From: Debbie Farrell [REDACTED]
Sent: 22 May 2019 15:57
To: Anita Gardner
Subject: FW: A/175/18/PL - Caffyns Temporary Car Park Extension - Highways

From: Antonia Catlow [redacted]
Sent: 21 March 2019 14:57
To: Anita Gardner
Subject: A/175/18/PL - Caffyns Temporary Car Park Extension - Highways

compromised parking
 temporary parking - see plan
 3480-SK01A

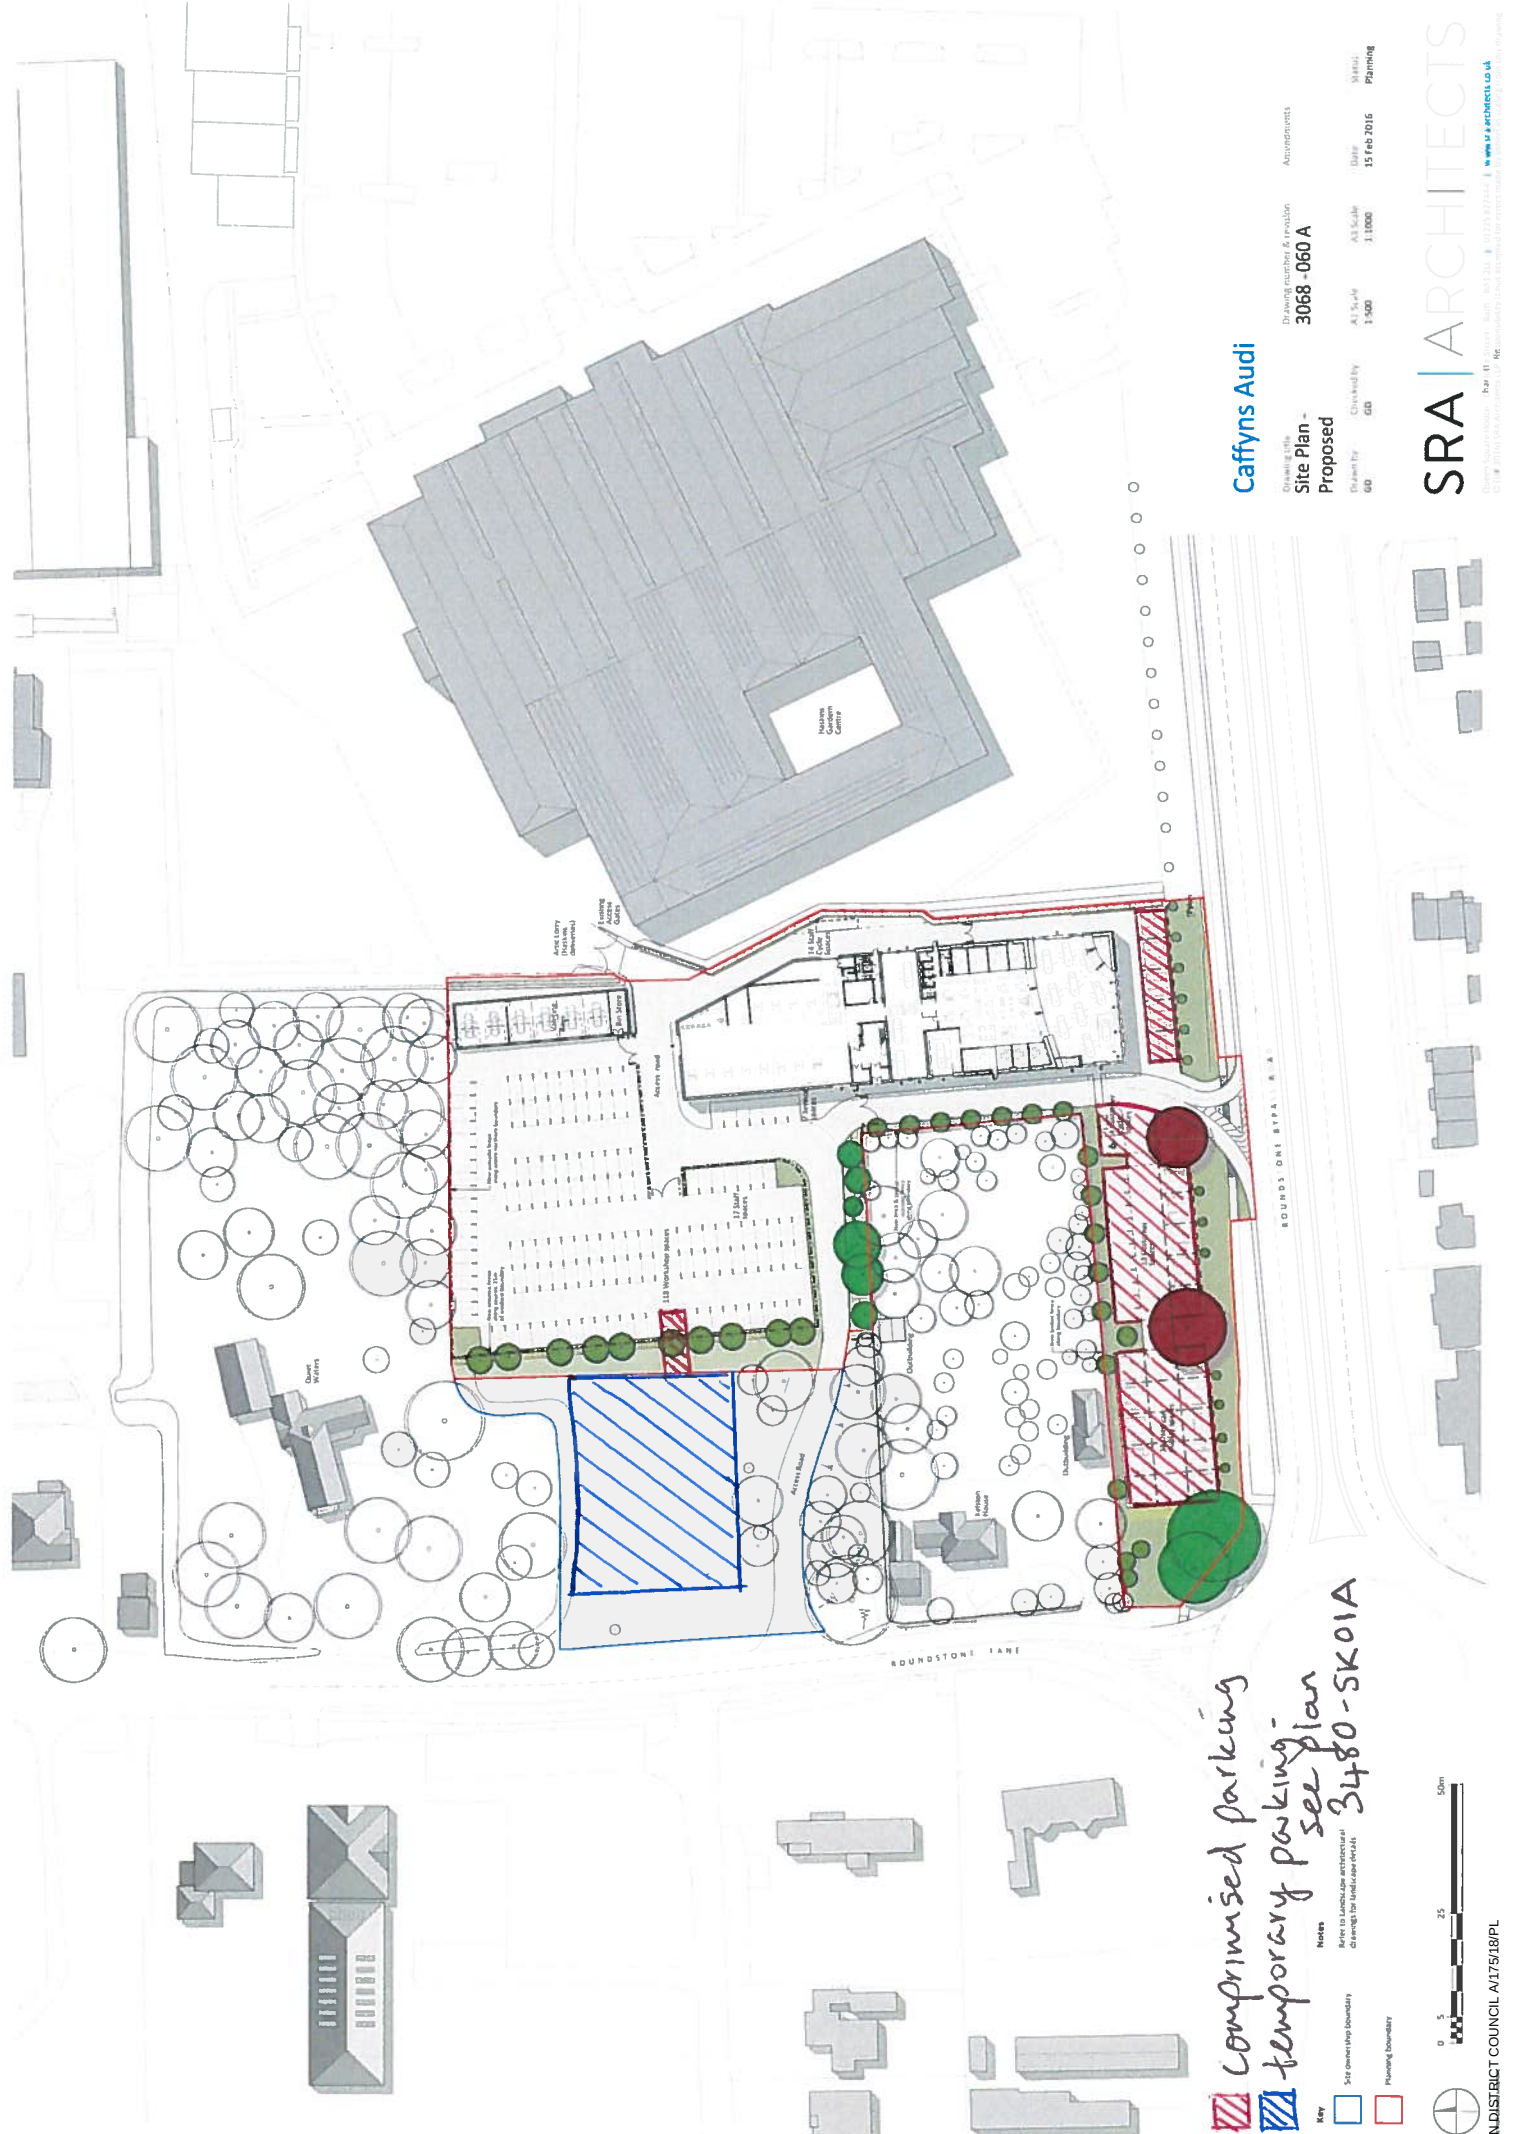
It can be seen from the attached site plan that access to the temporary car park can be gained from either the A259 and the Roundstone Lane access points. However there is a gate/fence between the building and the rear service area of the site presumably to stop customers driving through to the rear service area. The gate will need to be removed and clear signing installed within the site to inform customers of the parking to the rear (if accessing from the A259).

Clear signage will be required on the A259 stating if the main access is open or closed to avoid confusion to drivers trying to access the site.

No highway objection subject to a commitment to internal and external signage.
